Applicant: Maine Investment Properties, LLC  
Address: <sup>by-</sup> 126 Veranda St (Lot A) (Tim McCony)

Submission Site Plan - 2013-058  
Date: 10/11/13  
C-B-L: 431-~~00~~M-005  
Permit # 0013-02269

### CHECK-LIST AGAINST ZONING ORDINANCE

ELEVATIONS

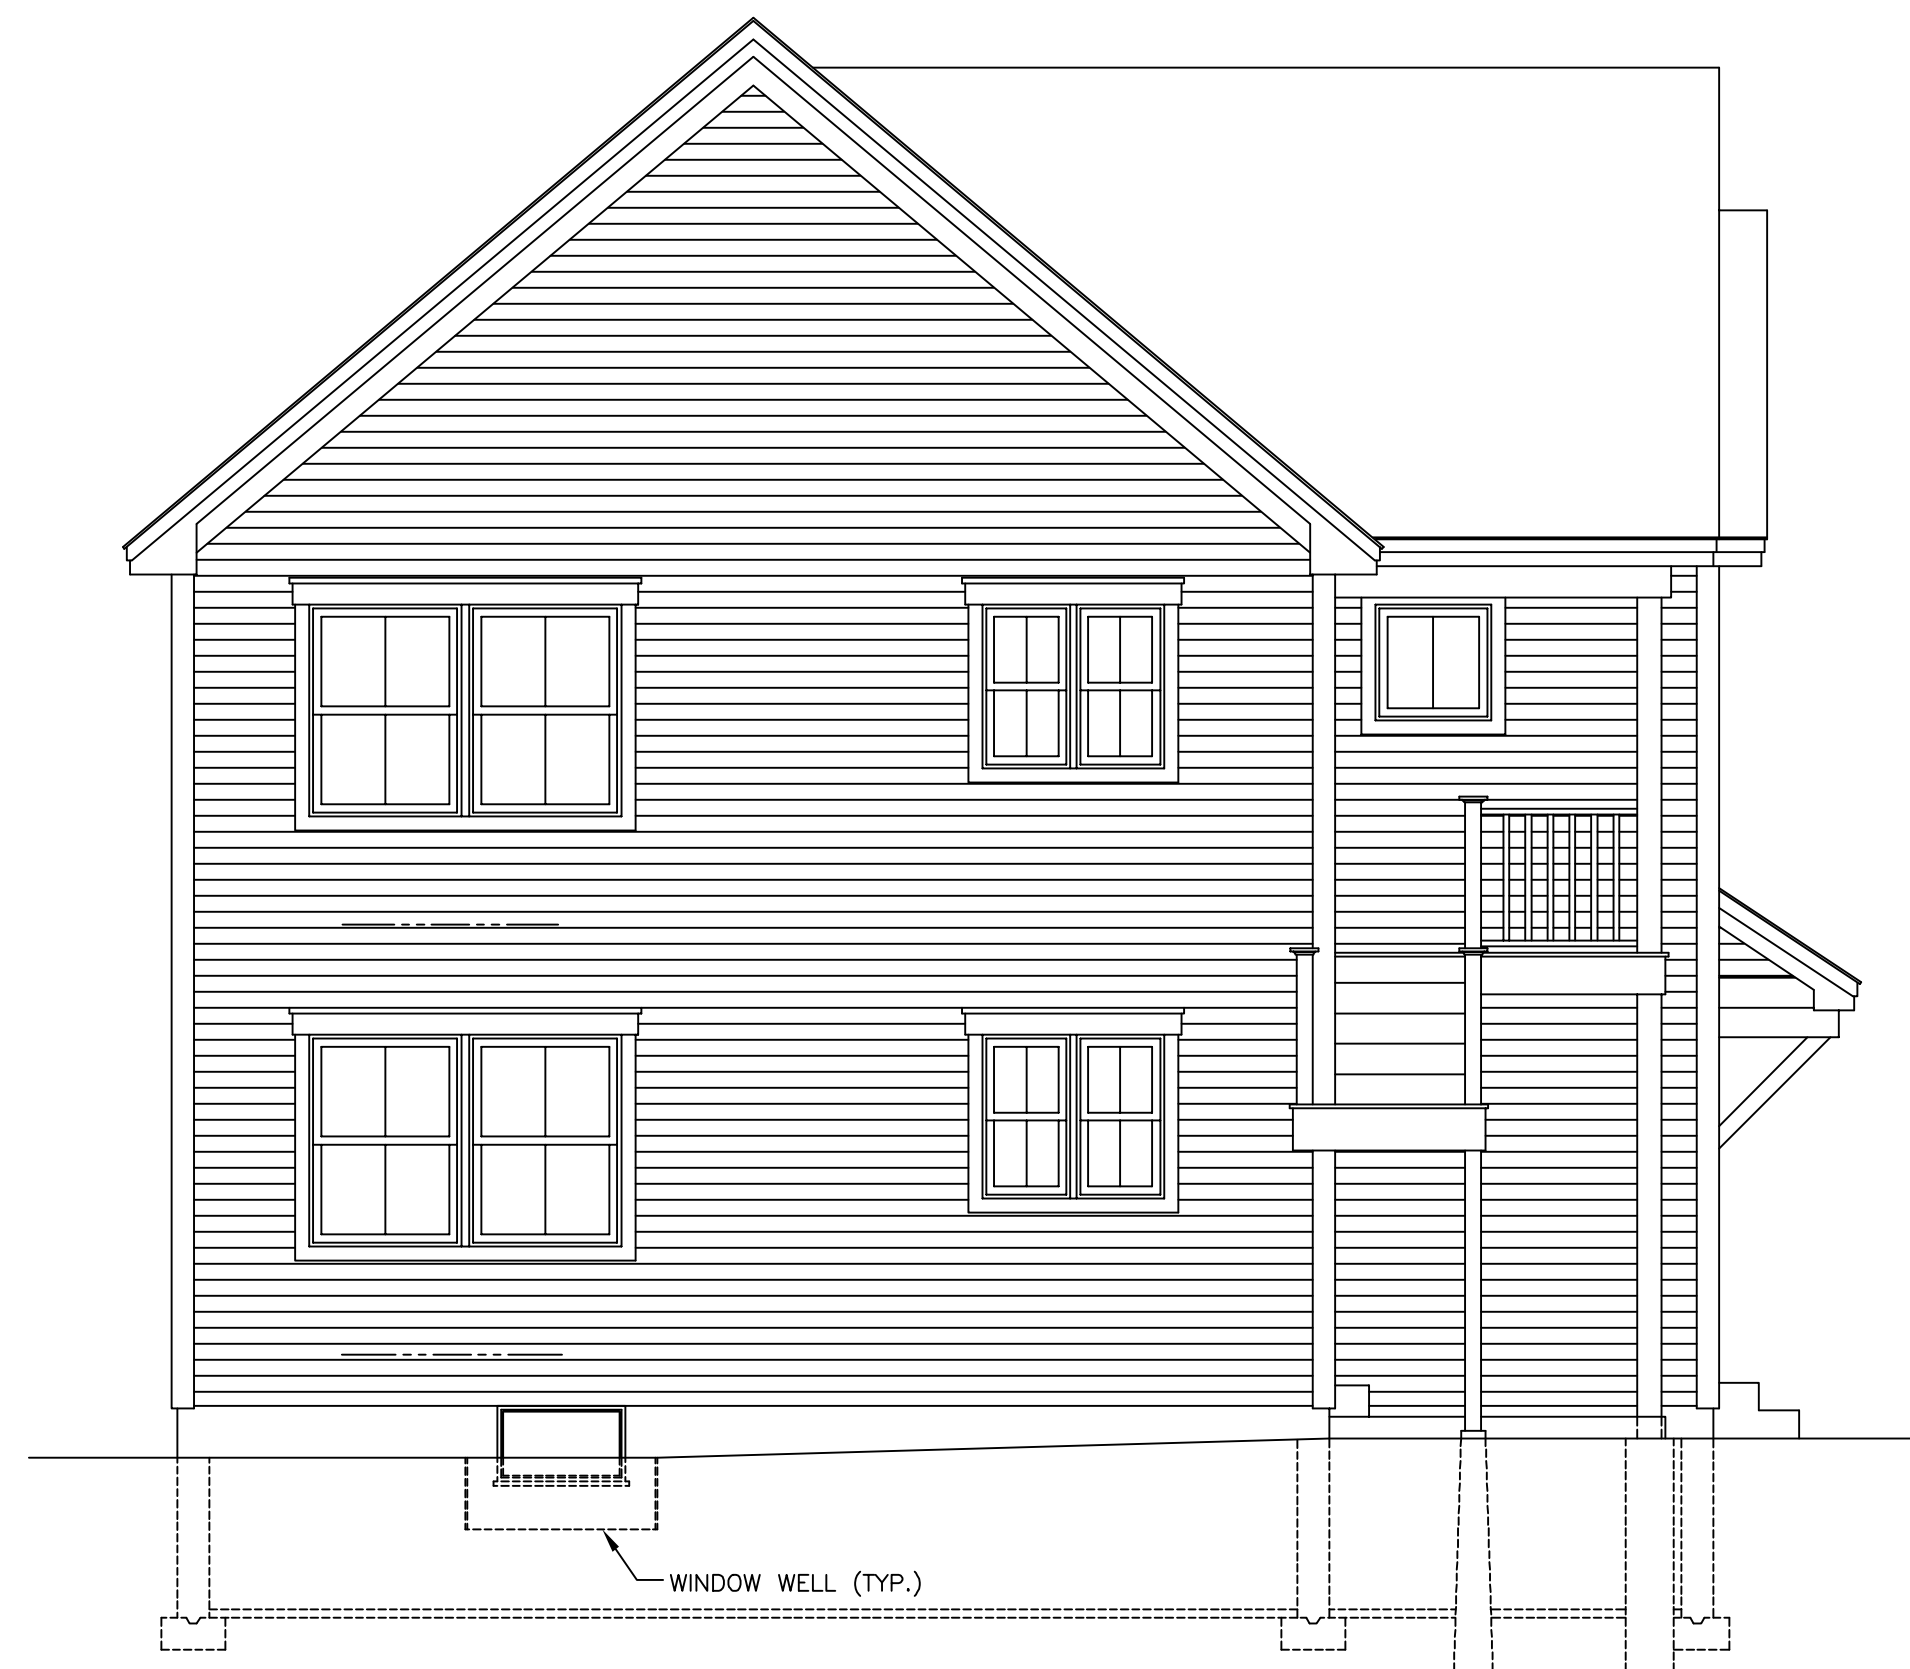
Front Yard - 20' or average - 21' scaled to bay window - OK

Height - 35' max - 29.5' scaled to ridge - OK

SITE UTILITIES & GRADING PLAN
PROPOSED SUBDIVISION
 120 VERANDA STREET
 OWNER: MAINE INVESTMENT PROPERTIES, LLC
 1651 BROADWAY
 SOUTH PORTLAND, MAINE 04106

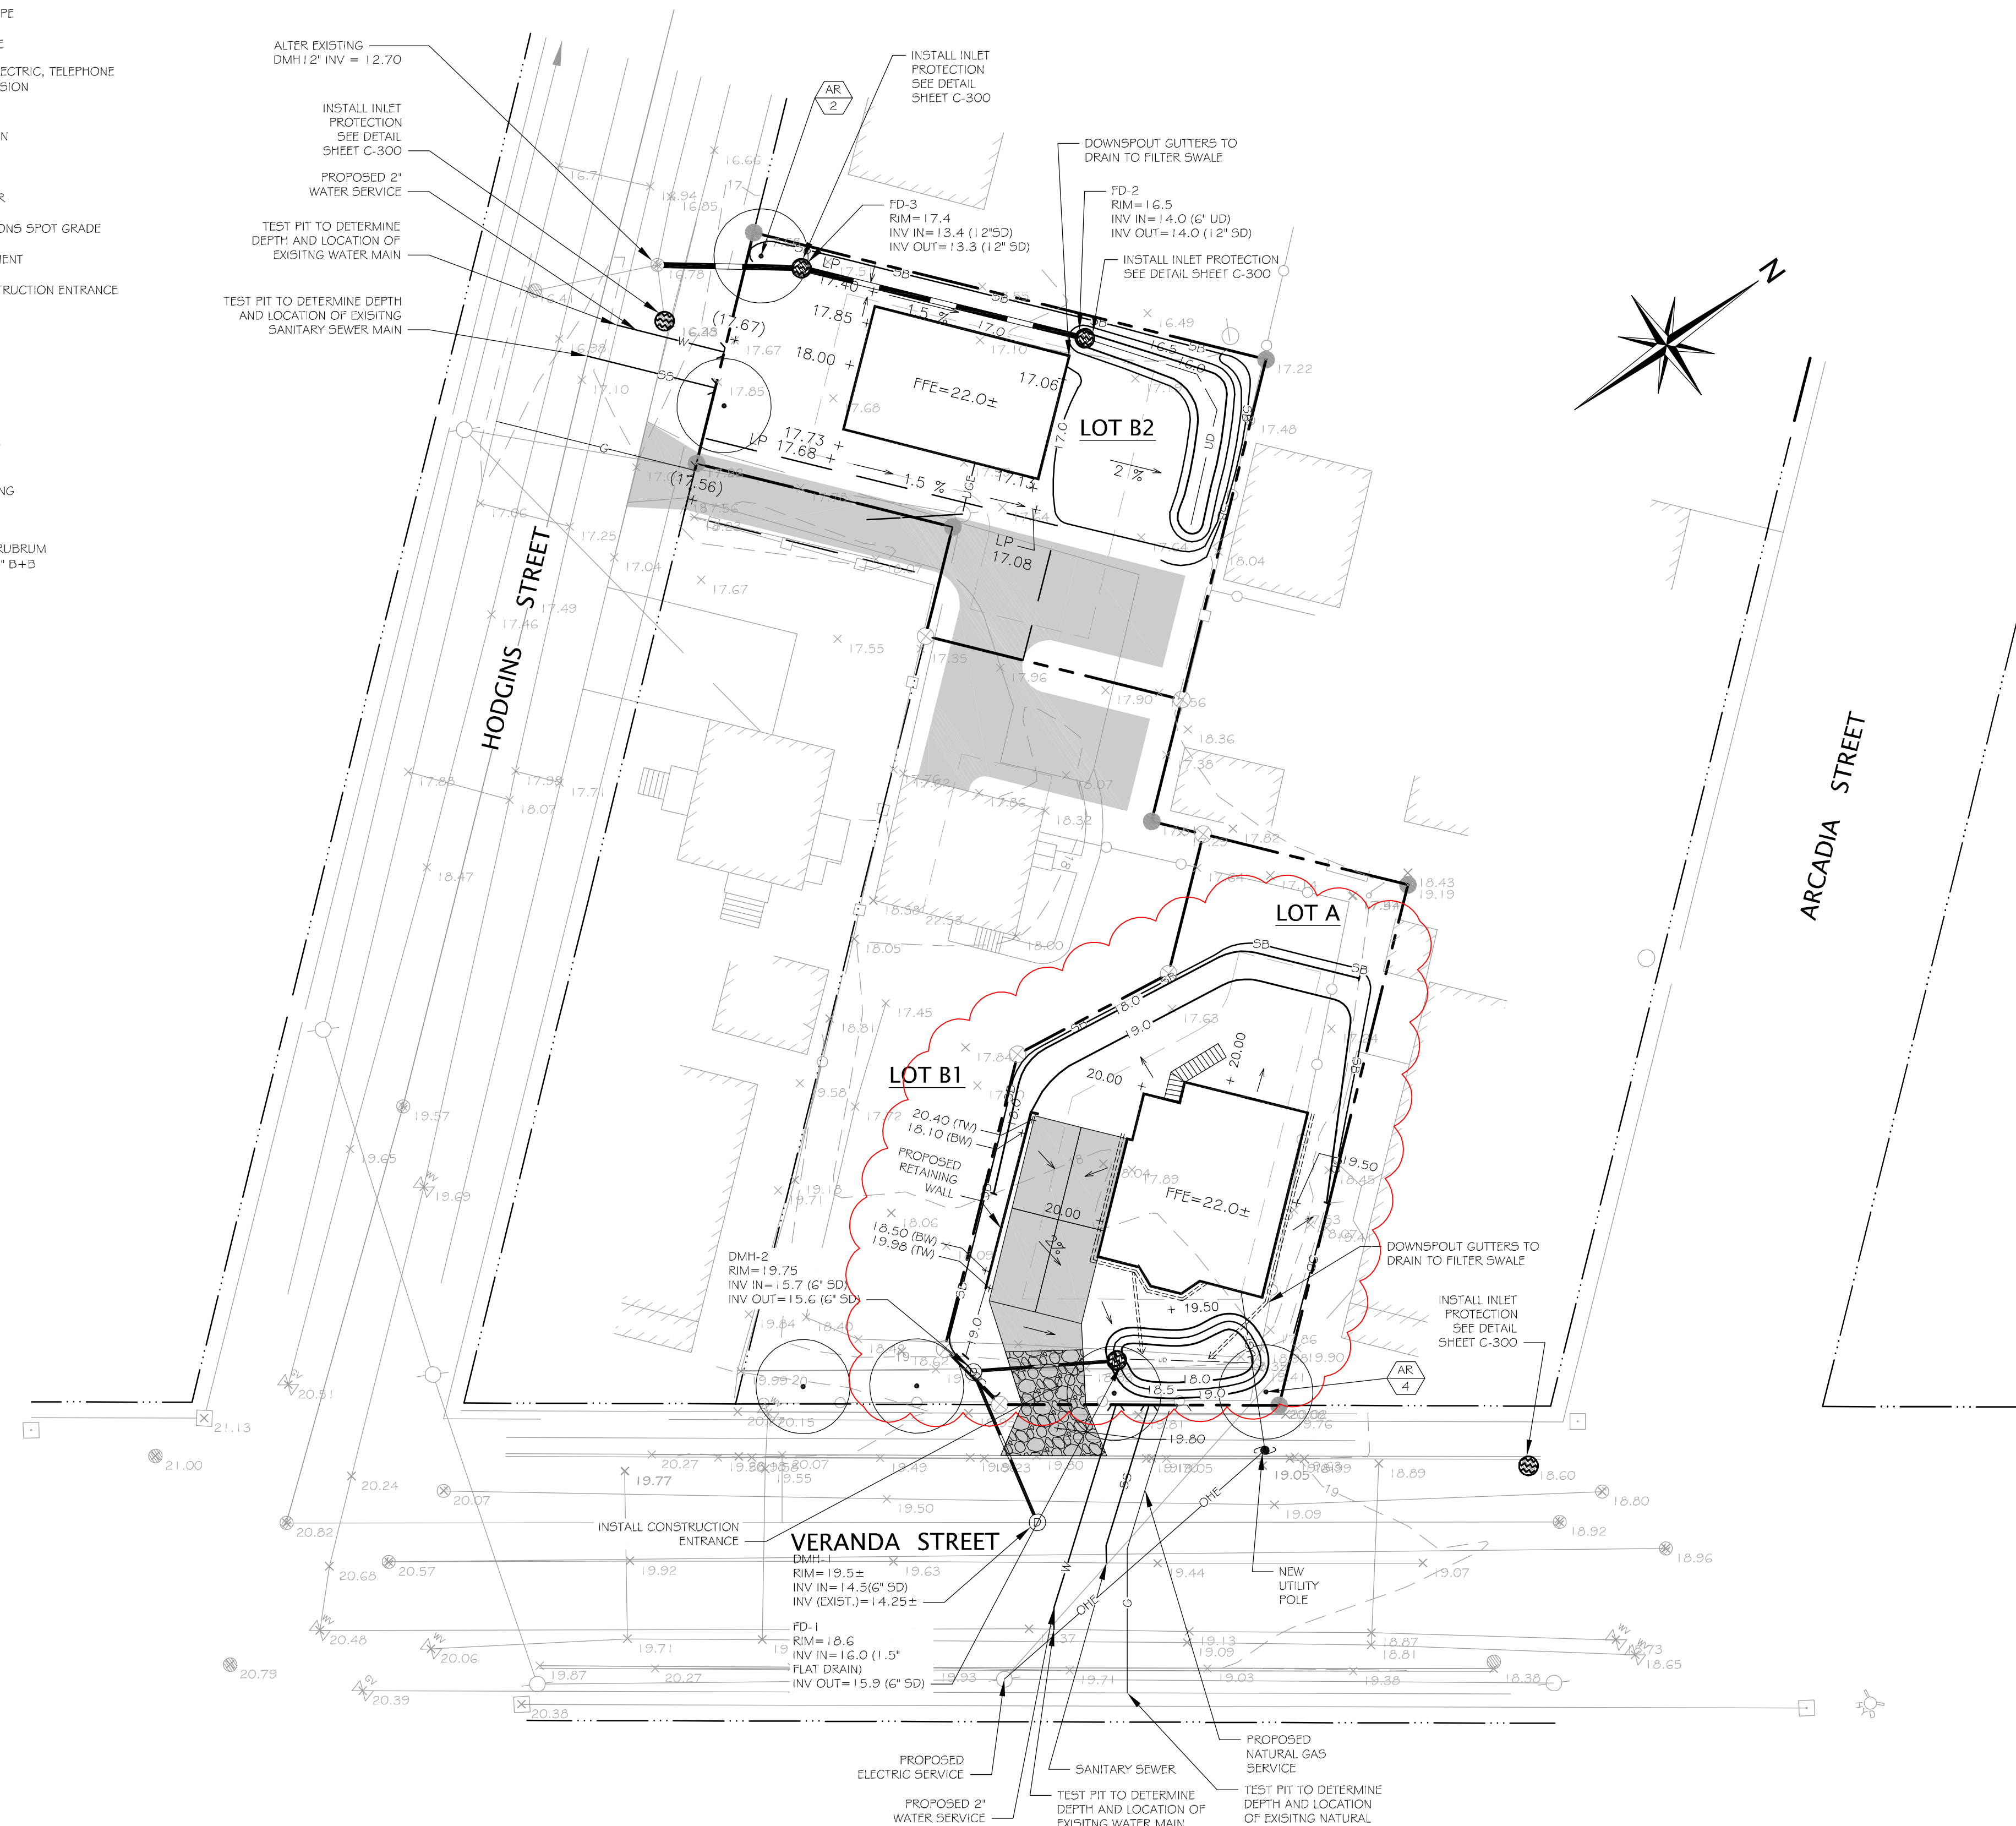
Lot Street Frontage - 50' min - 52.75' scaled

Rear Yard - 20' min - 37.66' scaled to stairs - OK

Side Yard - 2 sides - 12' min - 8' on right - OK on borrow from left - need total of 24' has 31.8'

Width of Lot - 60' min - 61' scaled rear of building - stairs are considered accessory and not part of principal structure - OK

Off-street Parking - 4 spaces required - 18x36 - 4 spaces

stair - 14-336  
can park in front yard for duplex if one driveway
